Cc: Michael Eastham <Michael.Eastham@arun.gov.uk>; Jamie Brown [REDACTED]
Bernadette Gledhill [REDACTED]
Subject: FW: Lyminster Bypass: CEMP

Section 14 'Traffic Management'

Please could you ensure that the CEMP refers to Lyminster Bypass (**southern section**) and Fitzalan Link Road (**northern section**) throughout the document.

MAIN SITE COMPOUNDS GA.
(TODDINGTON LANE)

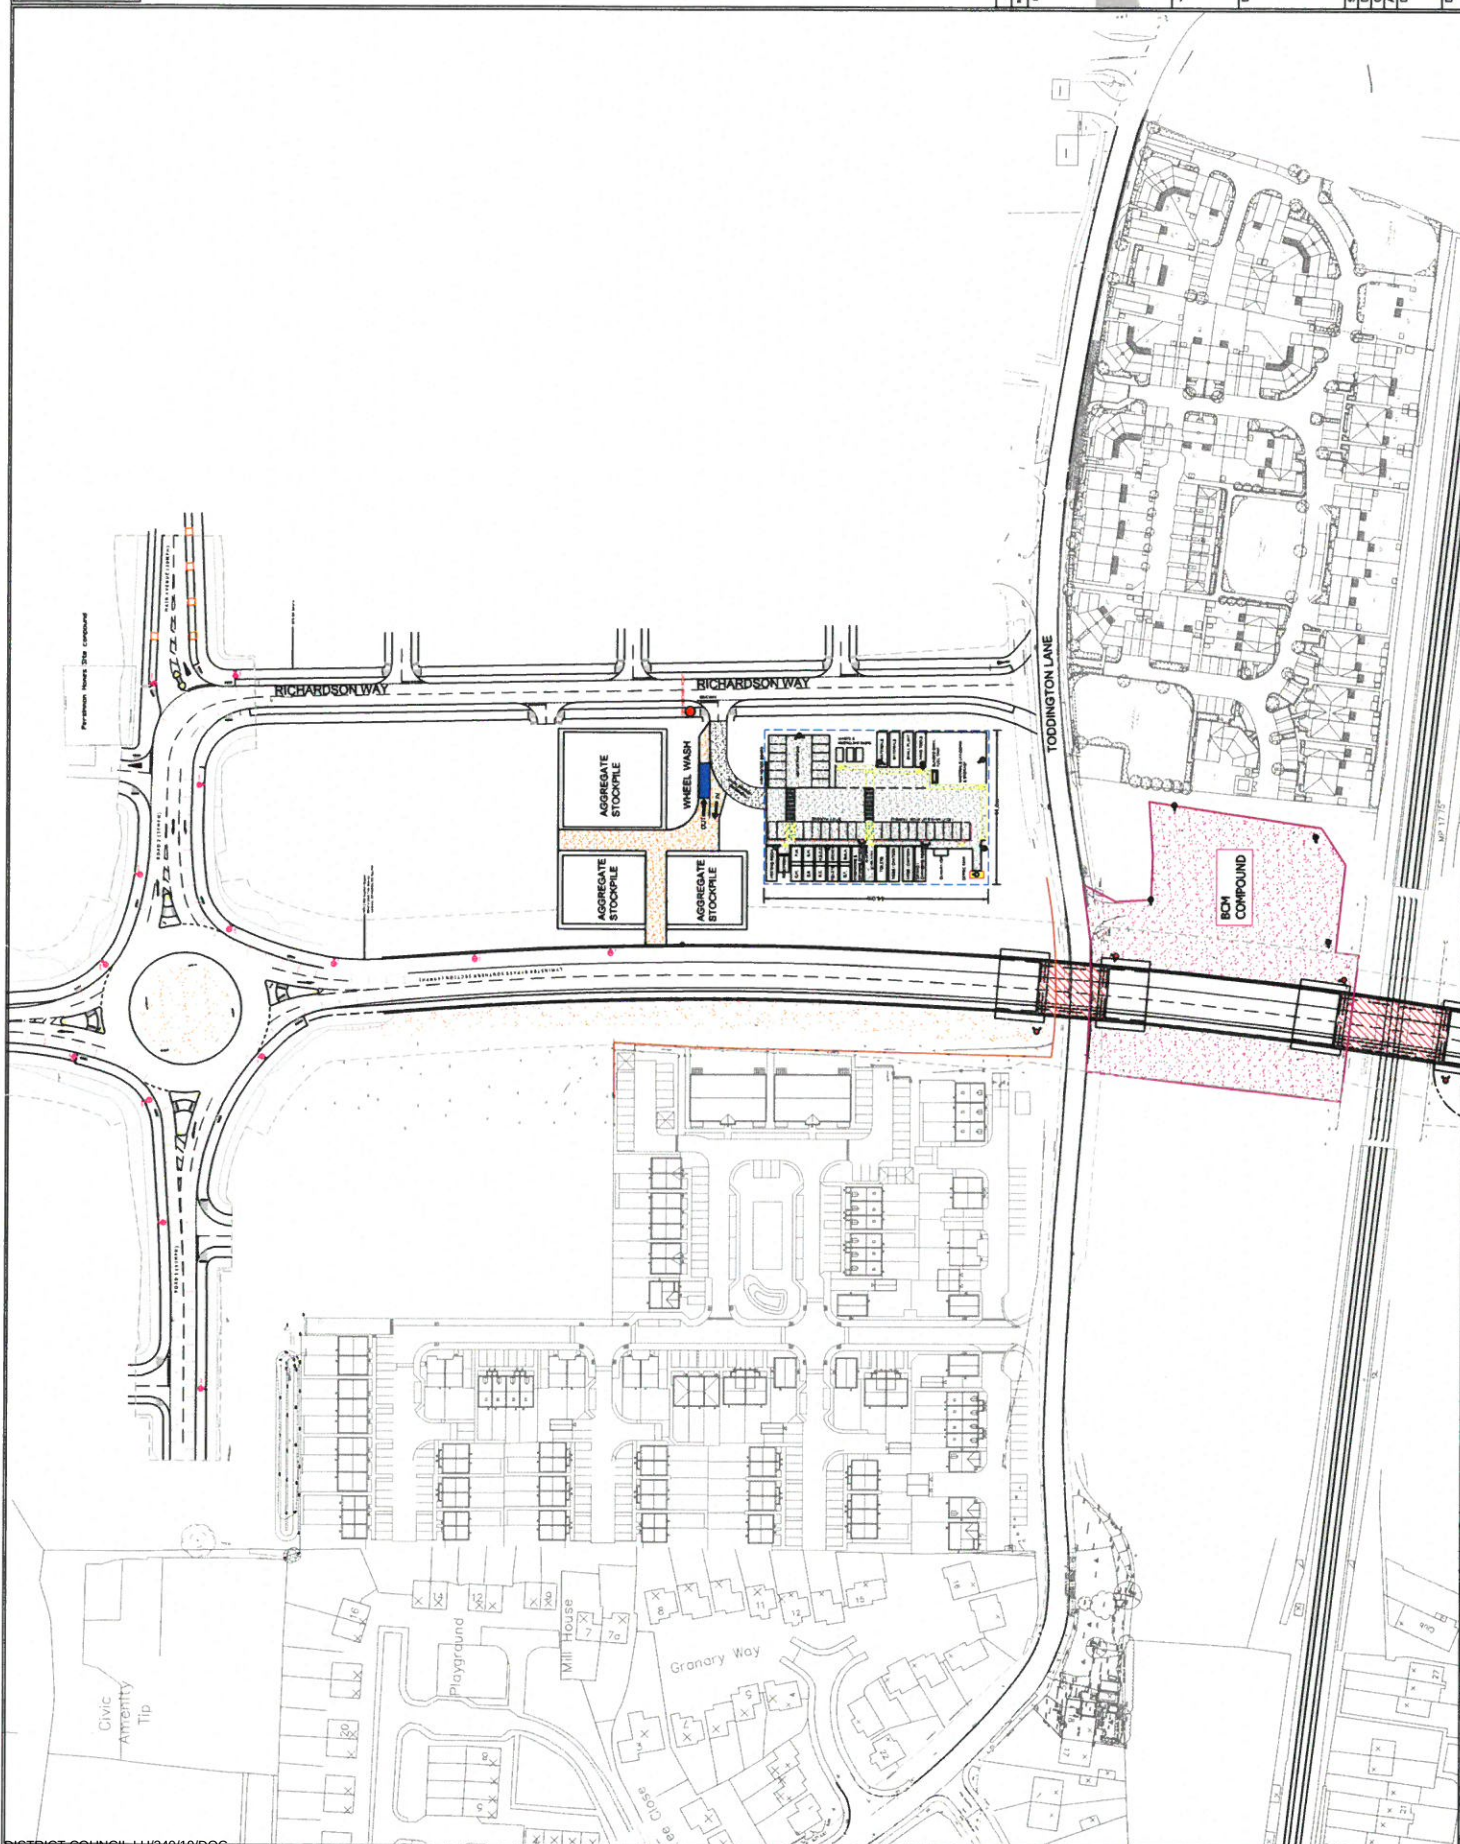
- Parking areas have not been demonstrated i.e not shown or laid out therefore difficult to know how much contractor parking could be housed. Clarification on the level of parking and its design and layout should be provided.

SITE DELIVERY POINTS.

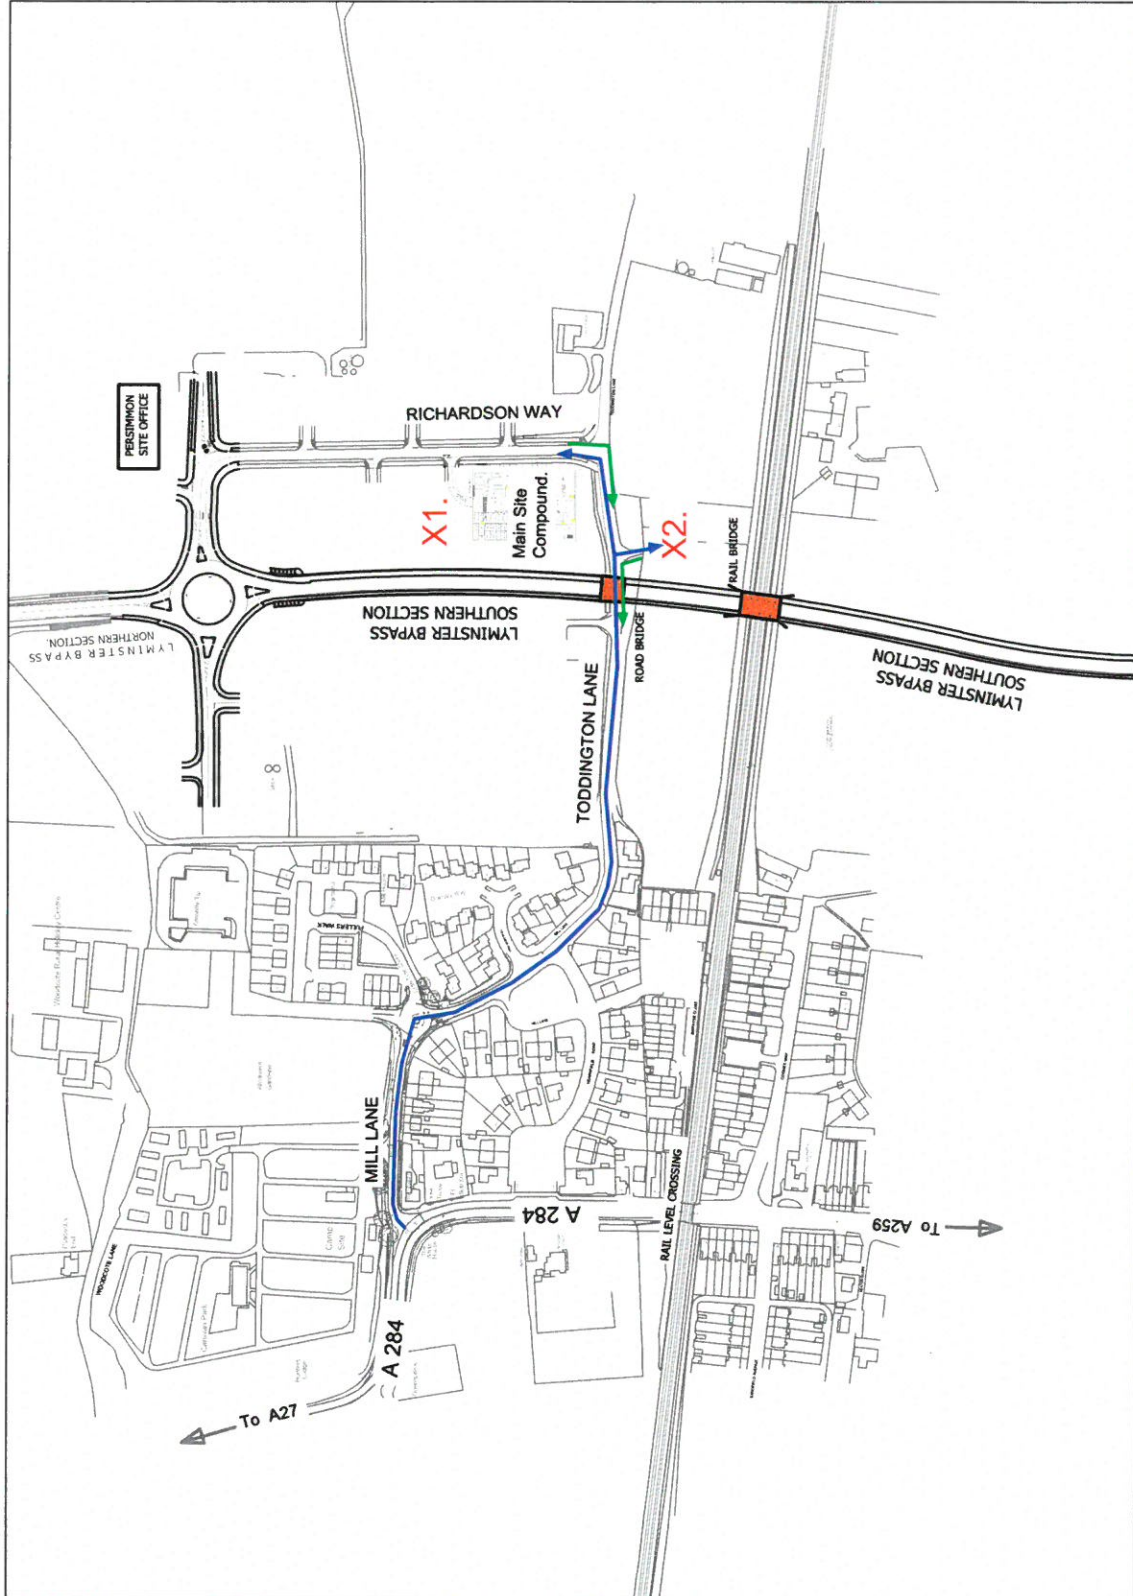
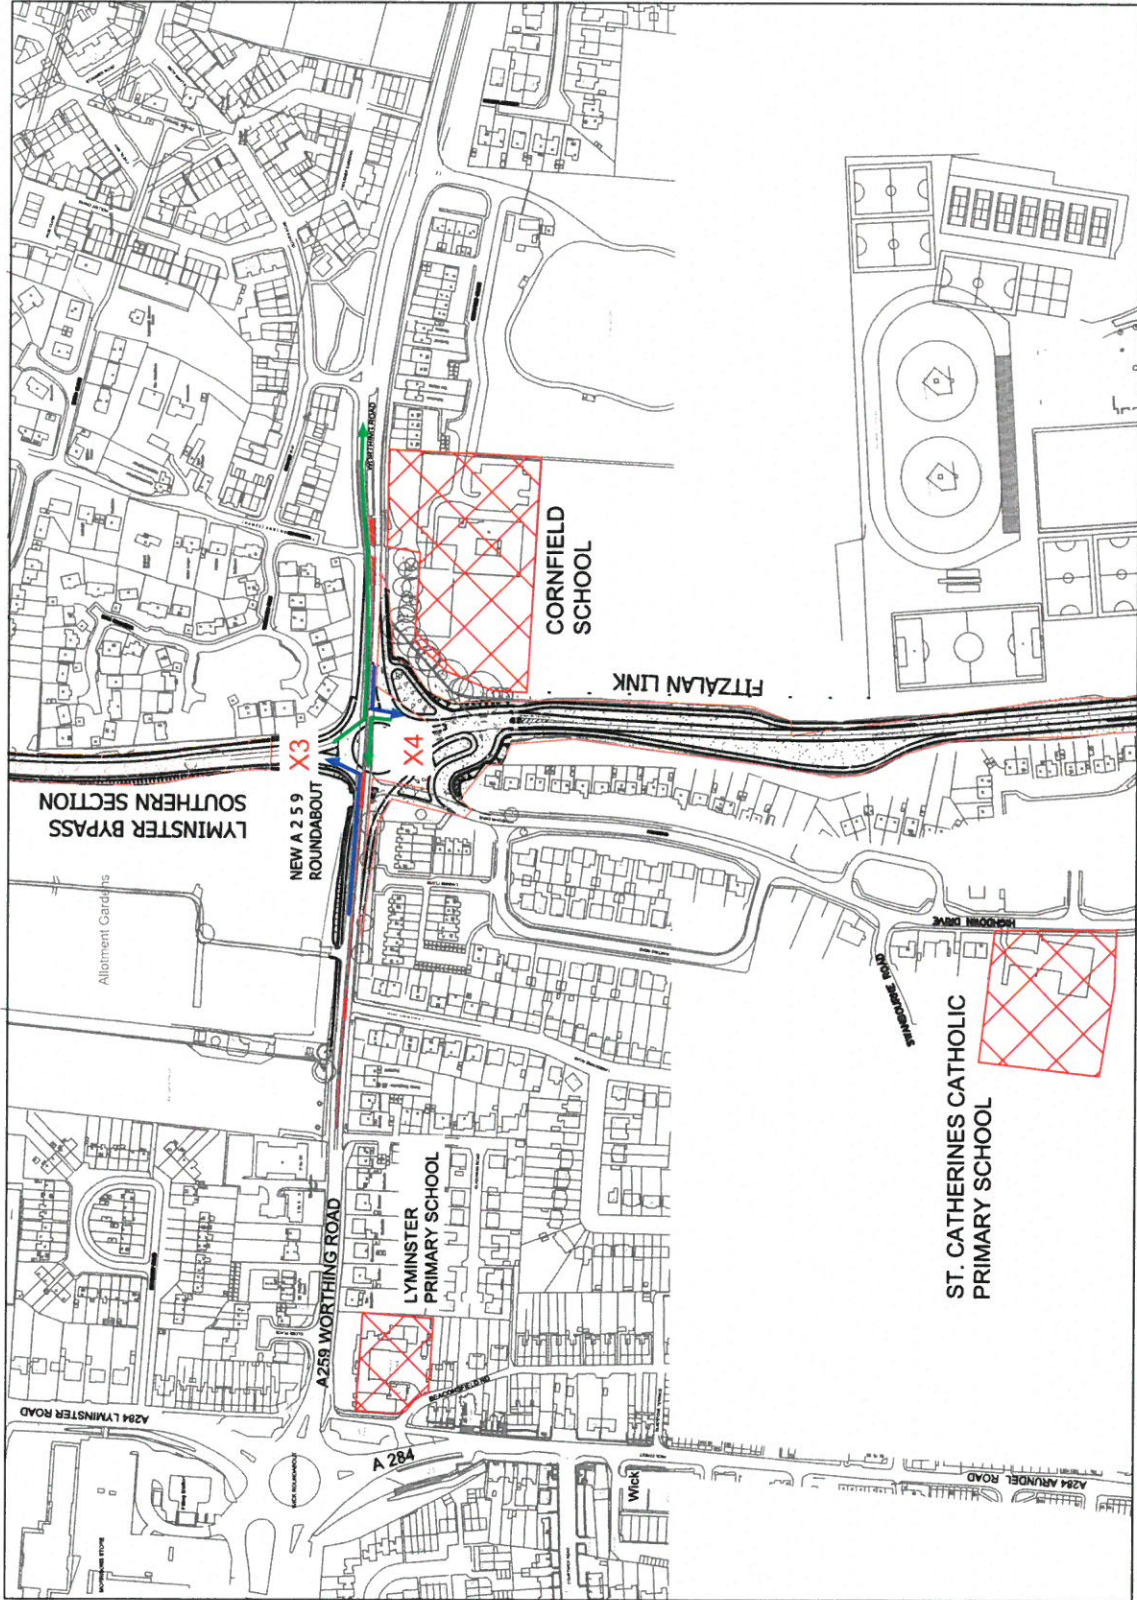
- Can the applicant confirm there will be no stacking on the highway during delivery times and that vehicles will load and un-load from within the site?
